About the application

Application number: 2026/91738	
What is the application for?:	Change of use from retail to retail coffee shop and bar with alcohol
Address of the site or building:	6, Station Road, Skelmanthorpe, Huddersfield, HD8 9AU
Postcode:	HD8 8DL

Type of comment: An objection	
Do you wish your comments to be published on the website anonymously?	Yes
Please do not publish any postal address, e-mail address or personal details online Dear Planning Officer, I am writing to formally object to the above-referenced planning application for a change of use from retail to a bar and coffee shop. Having reviewed the submitted documents, I have significant concerns regarding the completeness of the application, its non-compliance with local planning policy, and the detrimental impact the proposal will have on the adjacent conservation area and surrounding residential amenity. My specific grounds for objection are detailed below: 1. Inadequate Documentation and Validation Concerns The application as submitted is fundamentally incomplete, making it impossible to fully assess the impact of the proposed development. I question how this application was validated given the following om

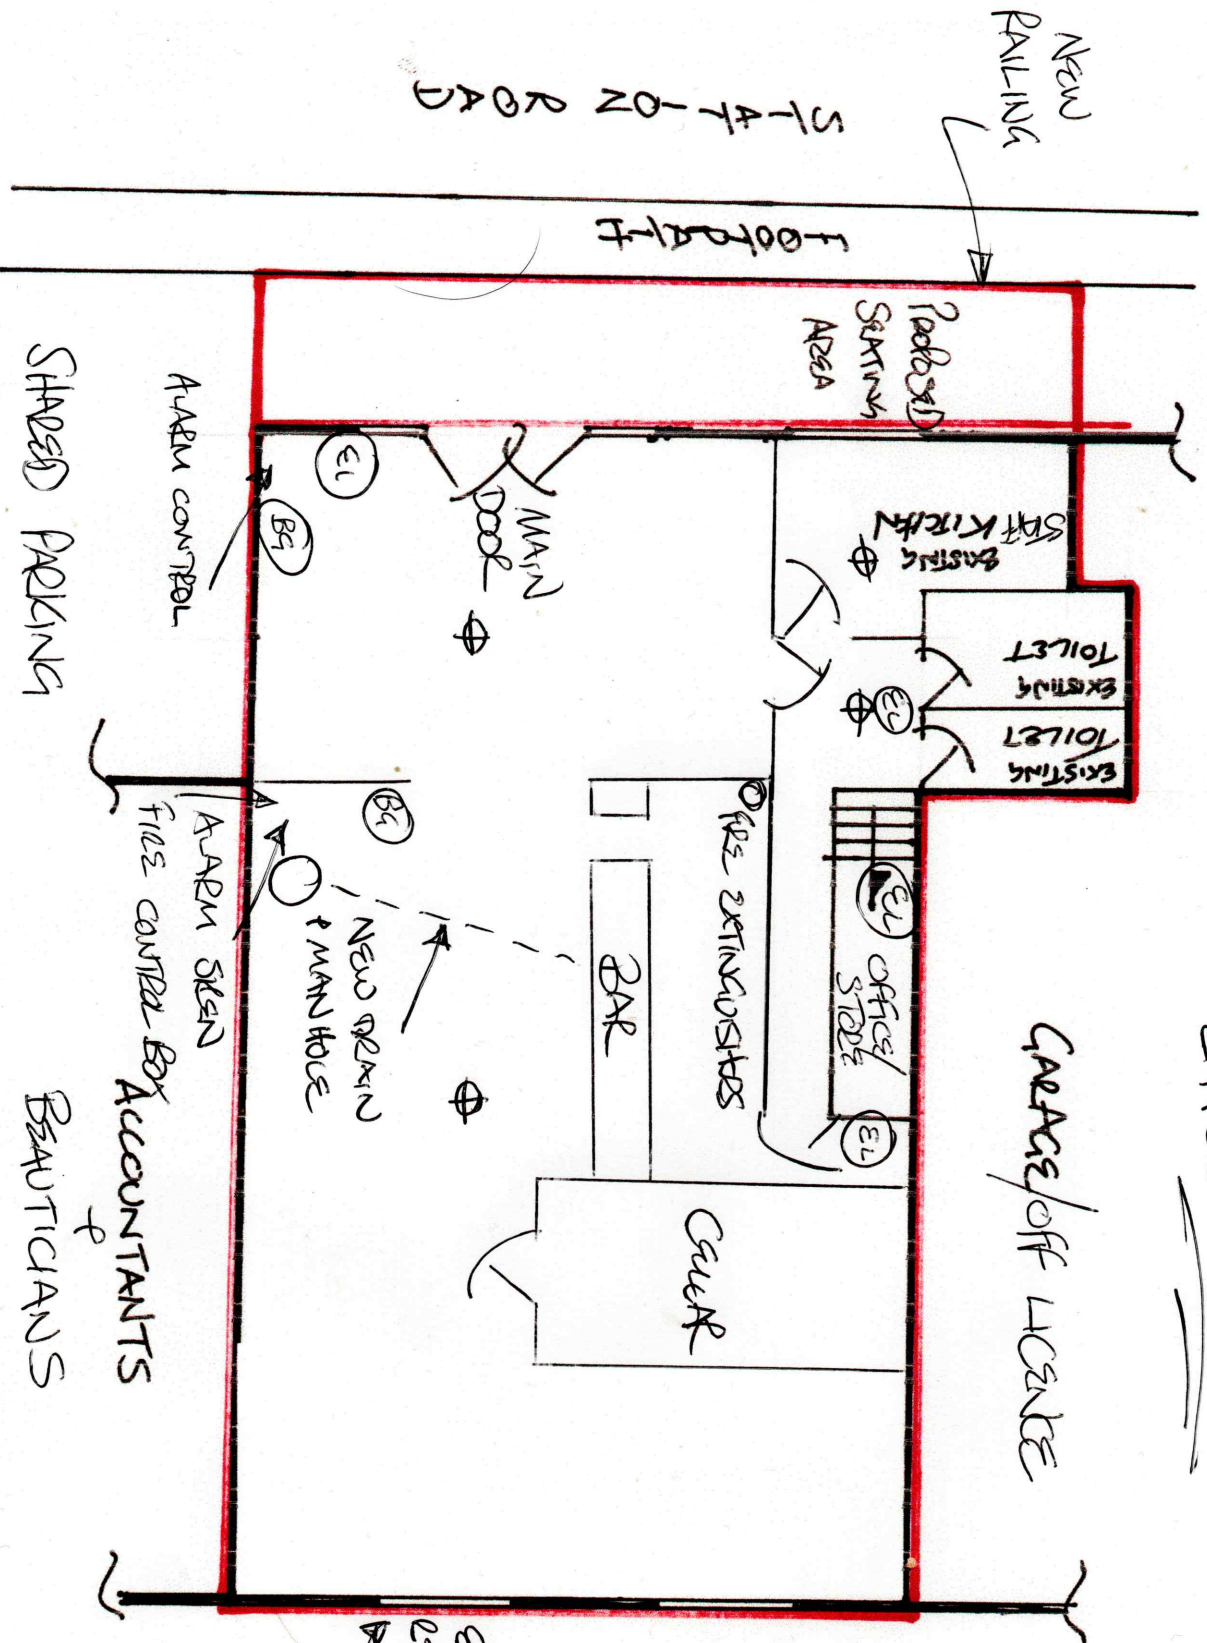
There is a significant discrepancy regarding the size of the premises. The application form states the floor area is 140 sq.m; however, dimensions taken from the submitted plans suggest a GIA of around 175 sq.m.

- This calculation assumes the ambiguous staircase does not lead to an additional mezzanine floor, which would increase the GIA further.
- This underrepresentation is critical, as surpassing the 150 sq.m threshold may trigger additional relevant policy requirements and impact the required application fee.

The plans lack clarity regarding the front entrance and its interaction with the public footway. It is unclear if new steps are being introduced to manage level changes, whether handrails and guarding will be necessary, or if access requires crossing adjacent land not included within the redline boundary.
